District: Cherwell

Application No: 18/00435/DISC

Proposal: Discharge of Conditions 2 (facing and roofing samples), 3 (door and window details), 7 (tree root barriers), 9 (access vision splays details), 11 (driveway and turning areas), 12 (parking and manoeuvring areas) and 16 (bat brick/box positions) of 17/00983/REM

Transport Development Control

HEYF-5-697

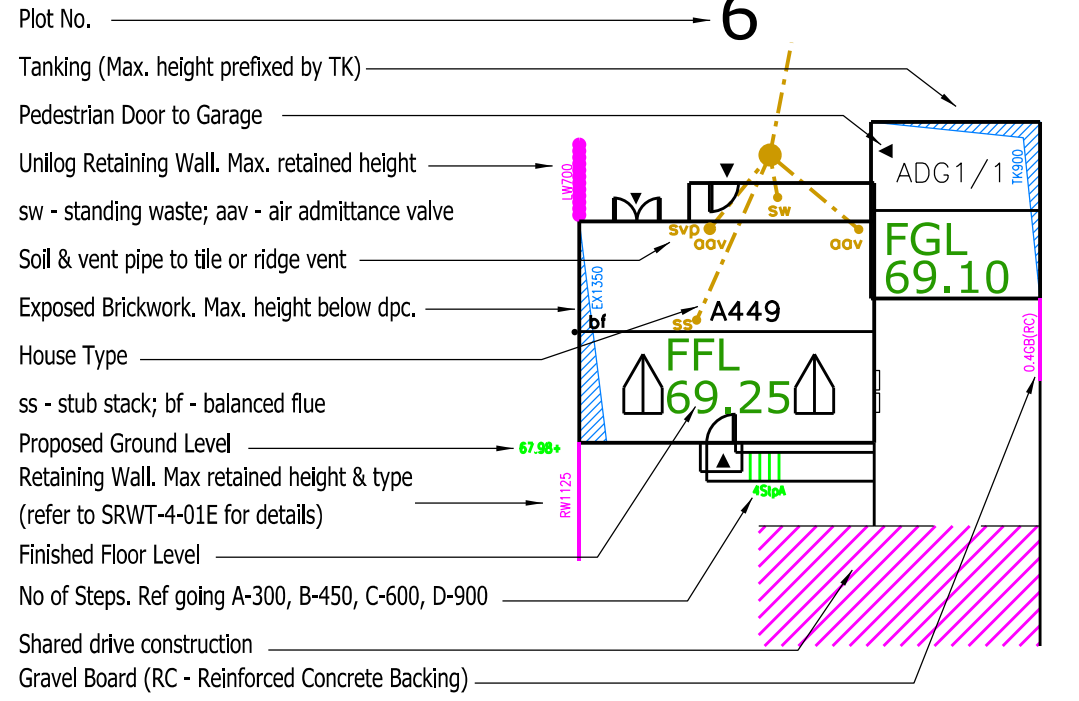
No vision splays are shown for the northern most access point on parcel B4A giving access to units 358 – 369. No vision splays are shown for any of the accesses to parcel B4B. **The County can not recommend discharge of this condition** until this information is supplied for review.

**Detailed Soft On-plot Landscape Proposals**  
**Heyford Park, Parcel B4B**  
 Client: Bovis Homes  
 DRWG No: B.0285\_120 Sheet No: ... REV: D  
 Drawn by: ASK Approved by: RVF  
 Date: 06/12/2018  
 Scale: 1:200 @ A1

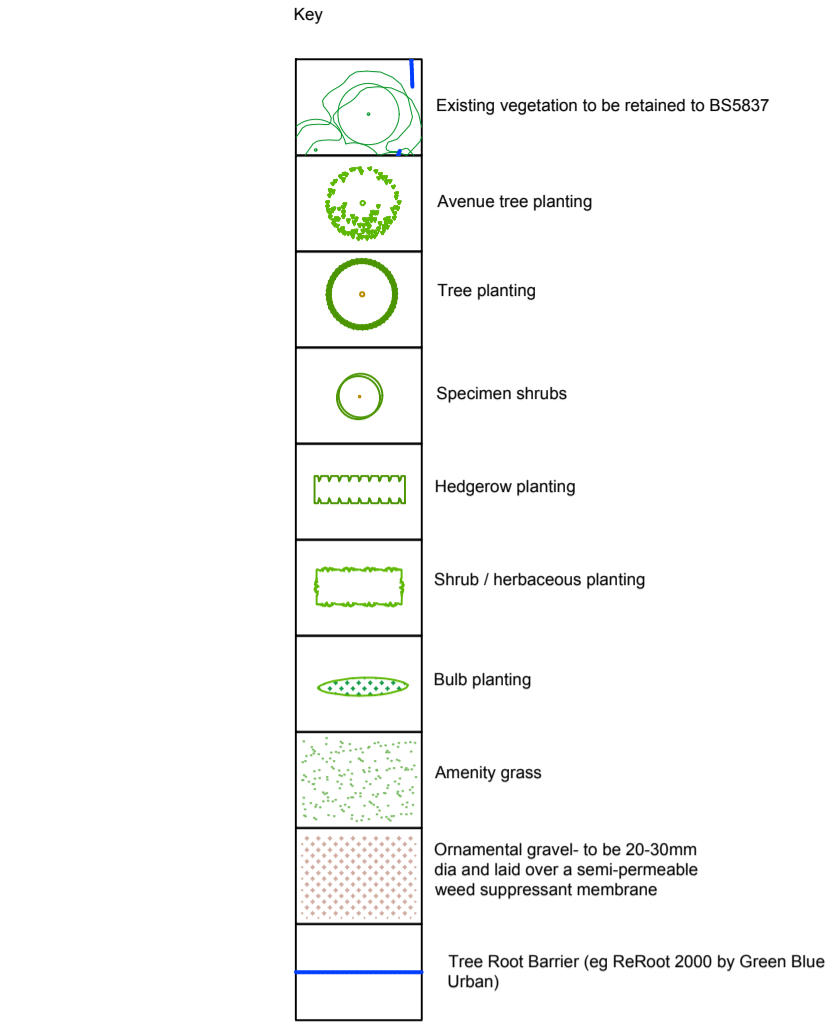
No information is supplied regarding tree root barriers. **The County can not recommend discharge of this condition** until this information is supplied for review.
